Comment for planning application 21/00565/F

Existing & Proposed  
 Site Plans

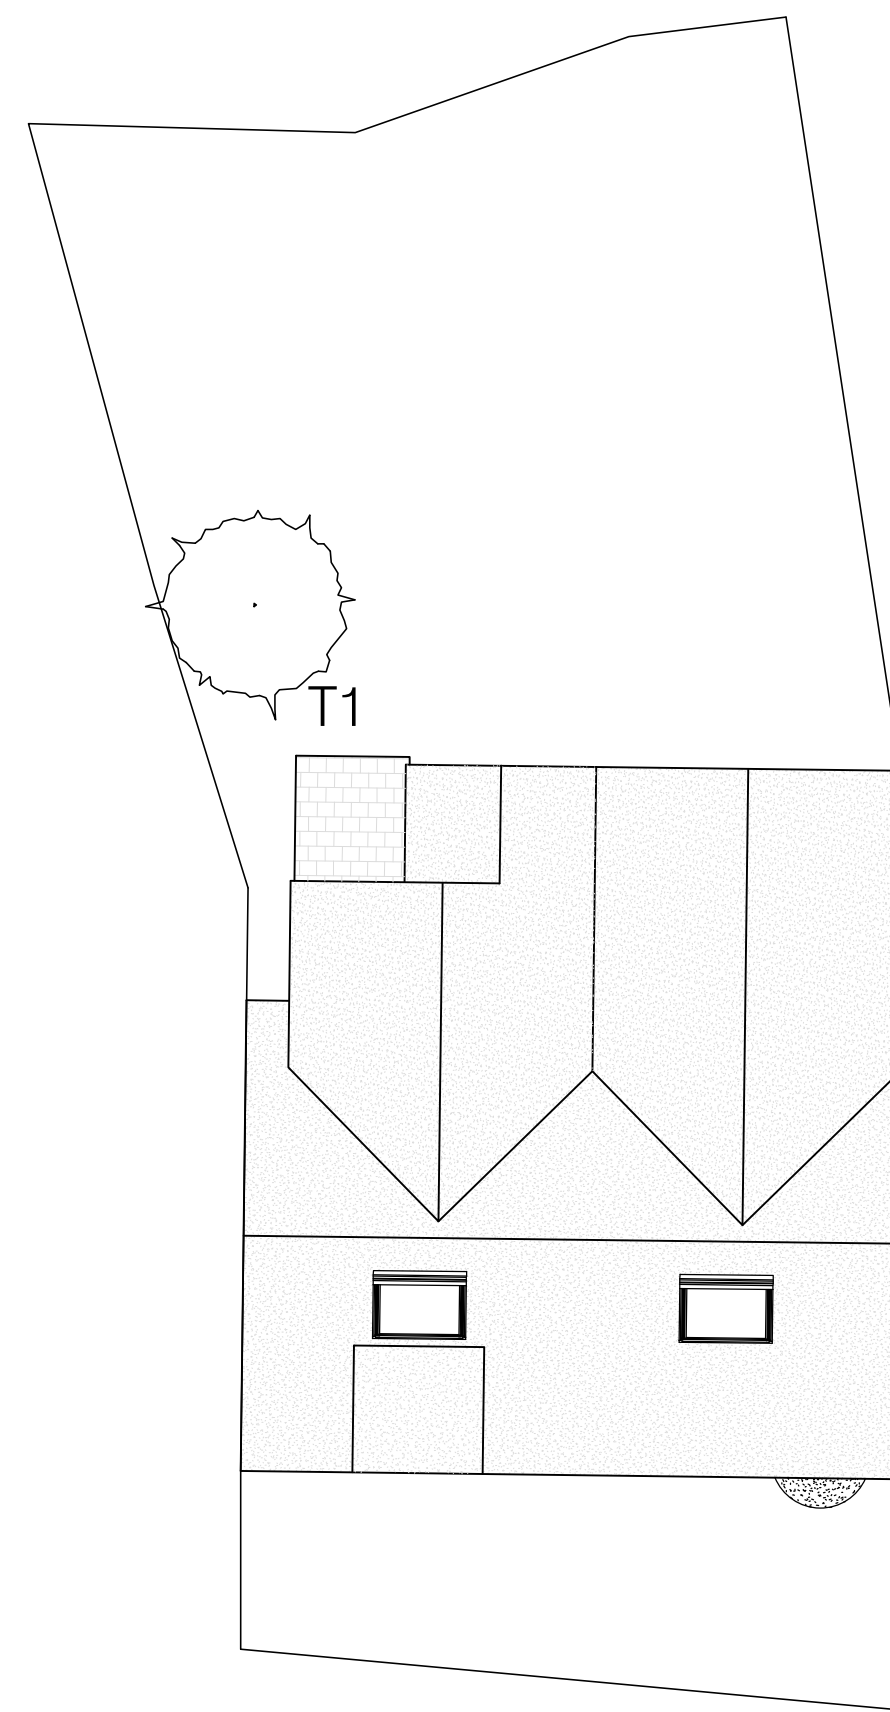
environmentally damaging oil spillage or leak as a direct result of this development; I believe the foul water and sewage run off for 1 Meadowcrest Cottages runs through one pipe which serves the two cottages to the right of it. This may not be able to cope with the extra demand placed upon it by more bathrooms/toilets and more people living there; If it was approved, I believe the disruption to the area would be off the scale with, I imagine, the lane having to be blocked off to allow a crane to lift materials over the roof to the rear of the cottage as there is no access to the rear apart from through the cottage front door. Skips for rubble would be needed which would have to be placed outside our cottages. Where would the residents be able to park while this work is ongoing? I wouldn't be able to park anywhere near my cottage for a considerable period of time. I like my vehicle parked where I can see it; There are plenty of properties in this area of the size and scale of this proposed development with 3 or more bedrooms and two bathrooms but with ample off road parking and infrastructure should someone wish to have a house of that size in this part of the world. But converting a small, historic cottage within a tightly packed, cheek-by-jowl row of cottages, into one of those houses will, in my view, irreparably damage the appearance and character of the cottage, the row of cottages and the conservation area itself.
